Recommendation Report for Planning Permission

REF NO: P/124/25/PL

LOCATION: Land to East of Commonmead Barn
Pagham Road
Pagham
PO21 3PY

PROPOSAL: 2 No single storey detached dwellings (with accommodation in the roof space) along with associated car and cycle parking (resubmission following P/9/24/PL). This application is a Departure from the Development Plan and is in CIL Zone 5 and is CIL Liable as new dwellings.

Fig 4. Route and depth of existing culvert

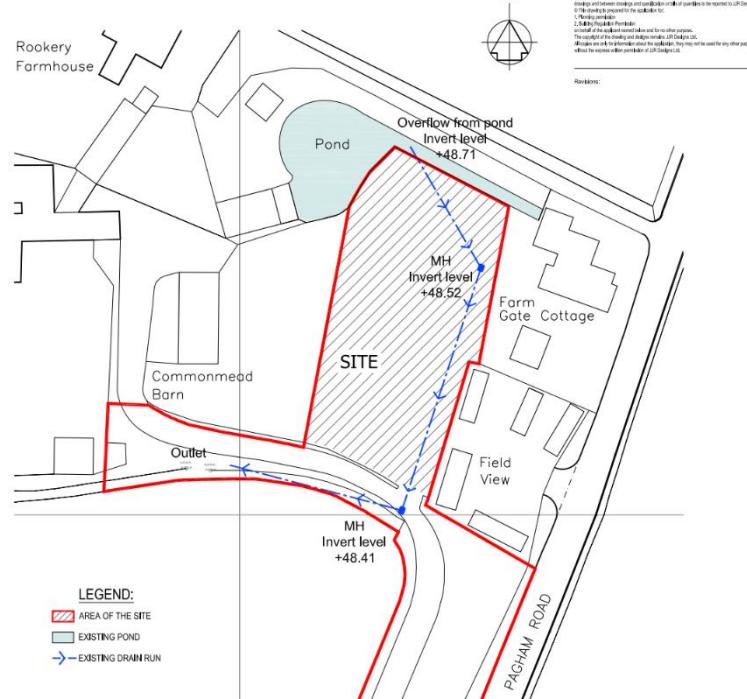
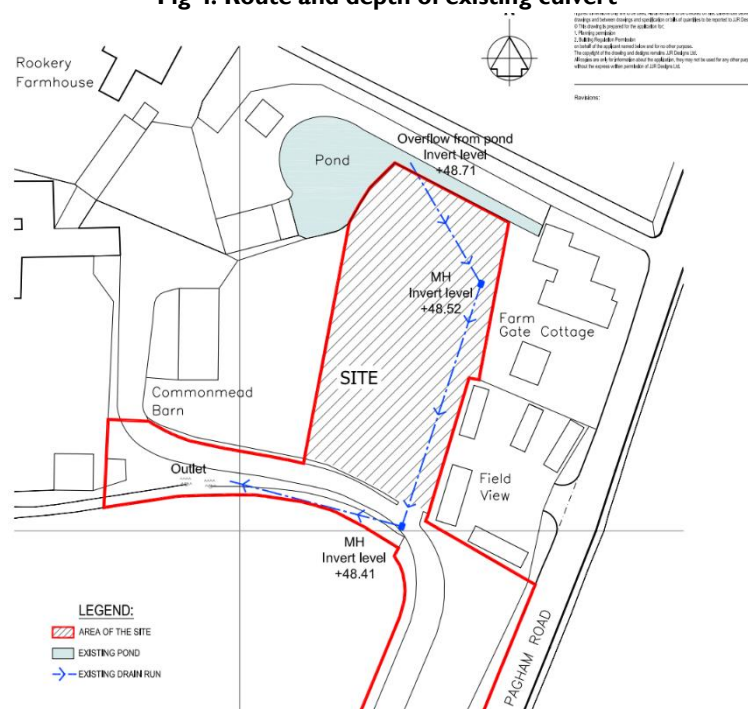
- The 3m easement between the culverted watercourse and the buildings is not shown and may conflict.
- The future year flood level at the site is not known, but due to the position on the edge of the extreme future flood zone, the risk of internal flooding to the dwellings will be low and we do not object on flood risk grounds.

- The report notes connection to the exiting culverted ordinary watercourse at a peak rate of 2l/s. This peak outflow rate is arbitrary and not restricted to greenfield runoff rates in conflict with the NSfS.

Scale: 1:200 @A3	Drawn:	Checked:	Date: 20.08.2025
Job No: 1683	Drawing No: PL 103	Revision:

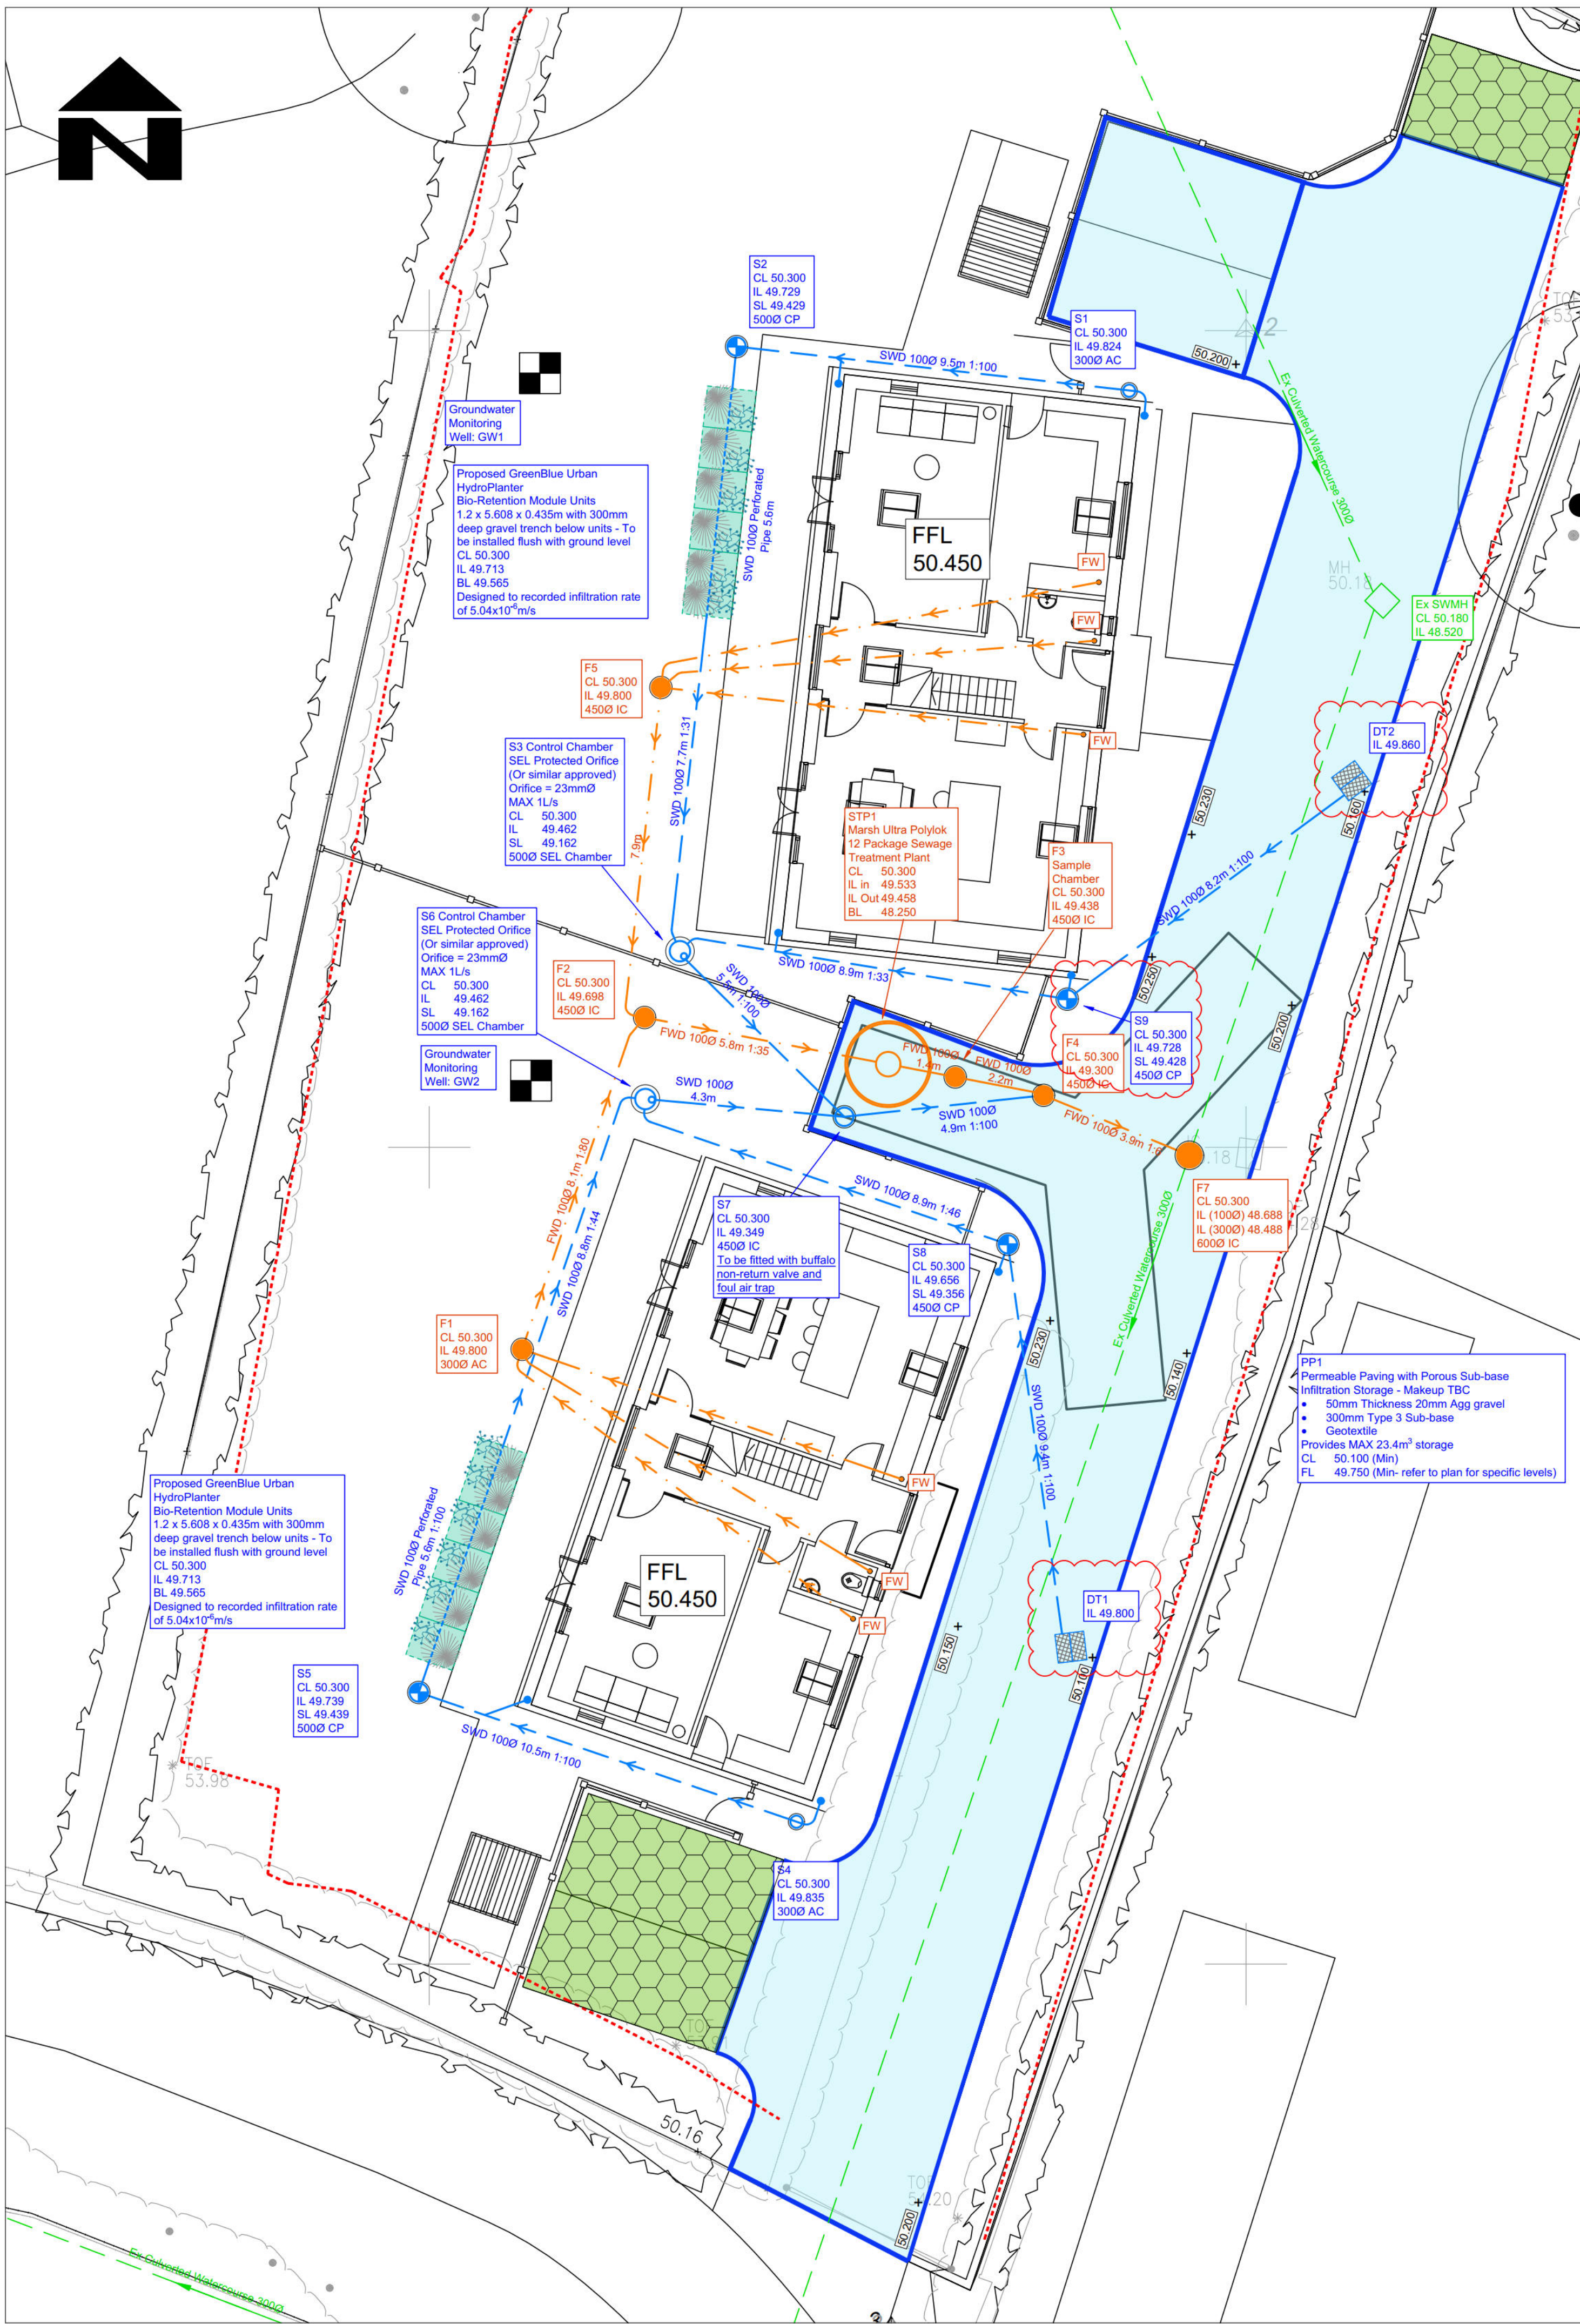
- A drained areas plan should be provided.
- Urban creep allowance is incorporated into the model simulations.
- Infrastructure within the permeable paving storage may reduce available capacity and any significant chambers and utilities margin should be removed from the plan area / volume calculation.
